**Jeanie Bourke - Re: 71 Quebec Street - Interior stair guard**

**From:** Jeanie Bourke  
**To:** Richard Lo  
**Date:** 6/5/2015 9:44 AM  
**Subject:** Re: 71 Quebec Street - Interior stair guard  
**CC:** Jonathan Culley; Phil Kaplan

Earlier today we discussed the balustrade guard & hand rail for the interior stair at 71 Quebec Street. In particular the guard height at the short end of the floor openings at 2nd & 3rd floor level - see attached PDF's:  
BMS-20150604-Interior stair guard-2nd floor.pdf  
BMS-20150604-Interior stair guard-3rd floor.pdf

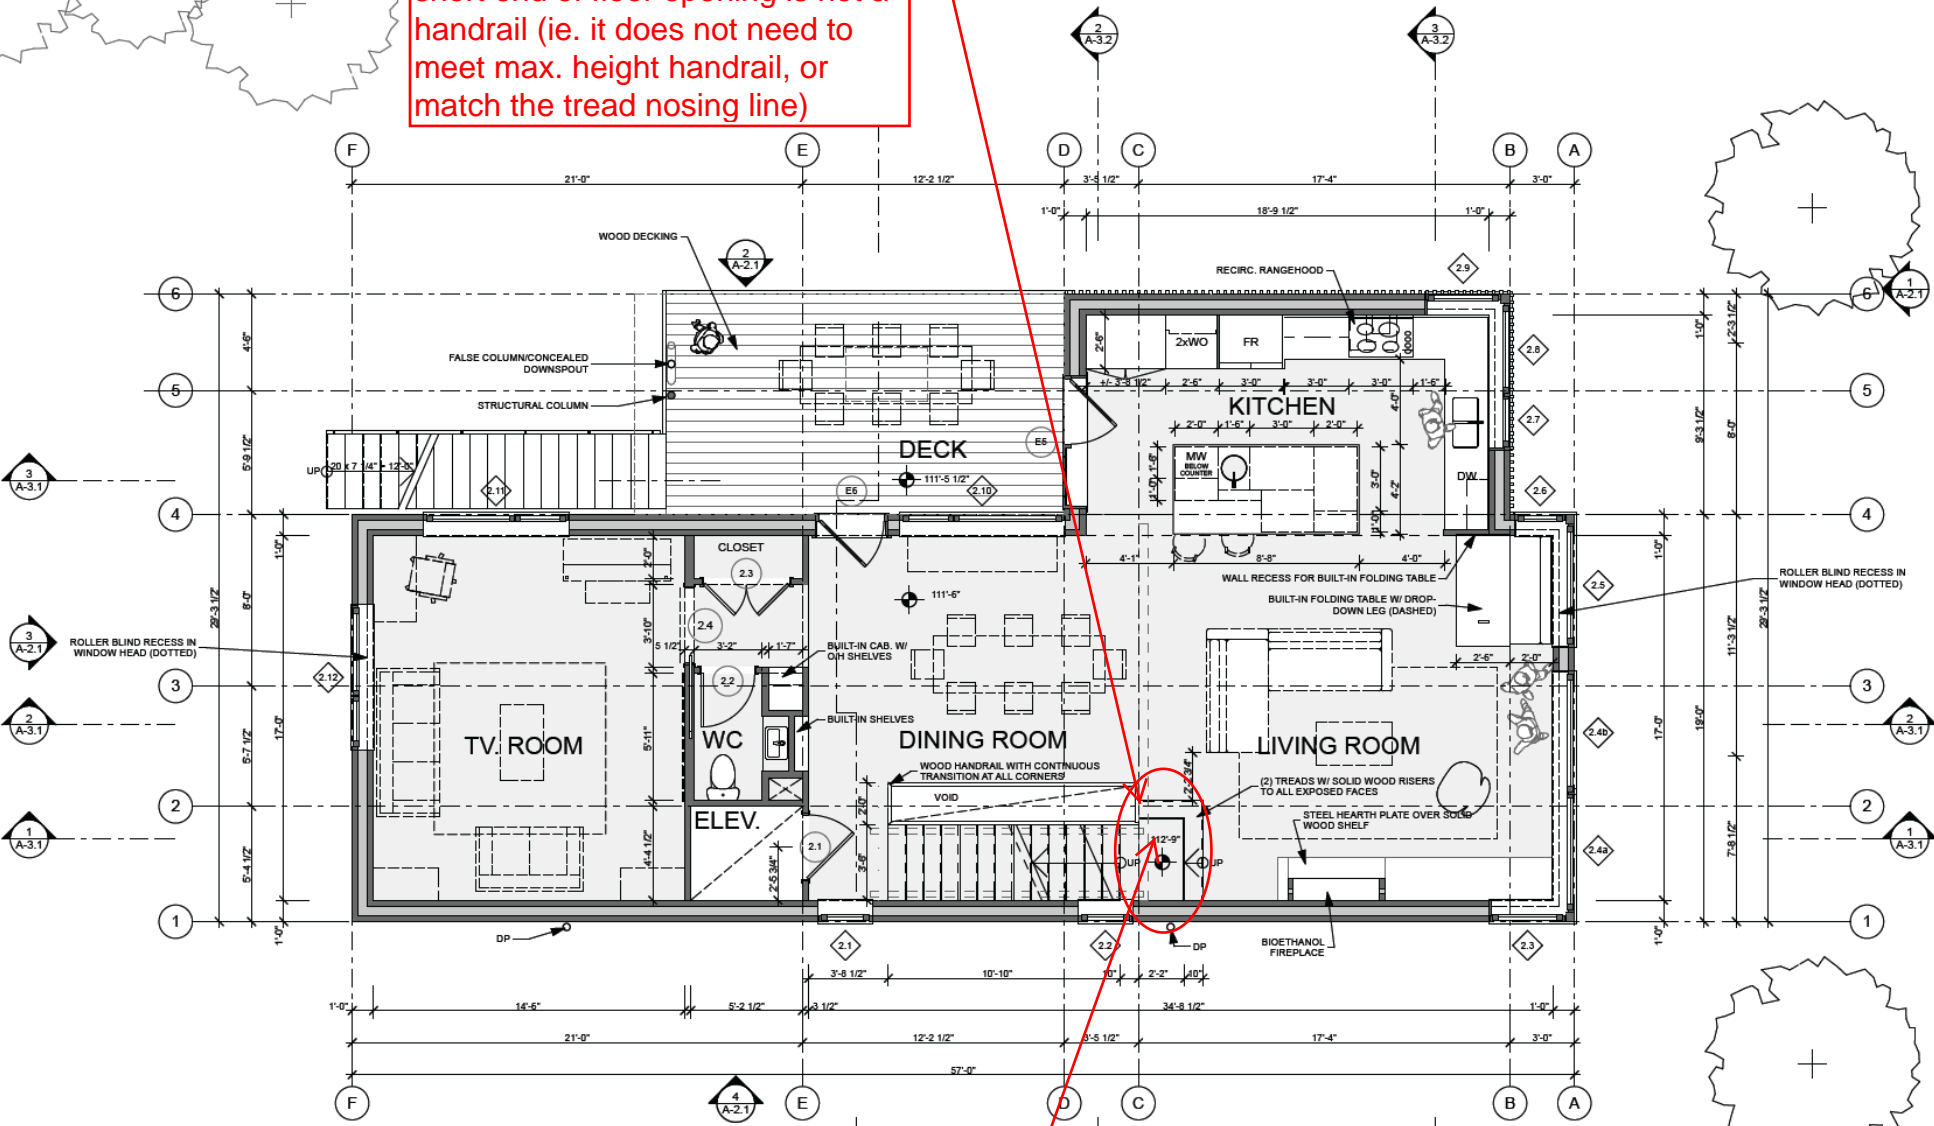
I understand that the 2 risers indicated at each floor level are considered a floor level change within the room (per IBC 1009.12, exception 5), & do not need a hand rail. A guard at the floor opening will be provided however.

Thank you for the follow up to our conversation yesterday. The exception cited is acceptable as designed and a handrail is not required at the floor elevation change for 2 risers.

I further read the commentary for Sec. 1009.12.5, which notes that the definition of a stair is *A change in elevation, consisting of one or more risers*. This confirms that it also applies to portions or flights of "stairs" with up to 3 risers with a floor or landing at the top and bottom.
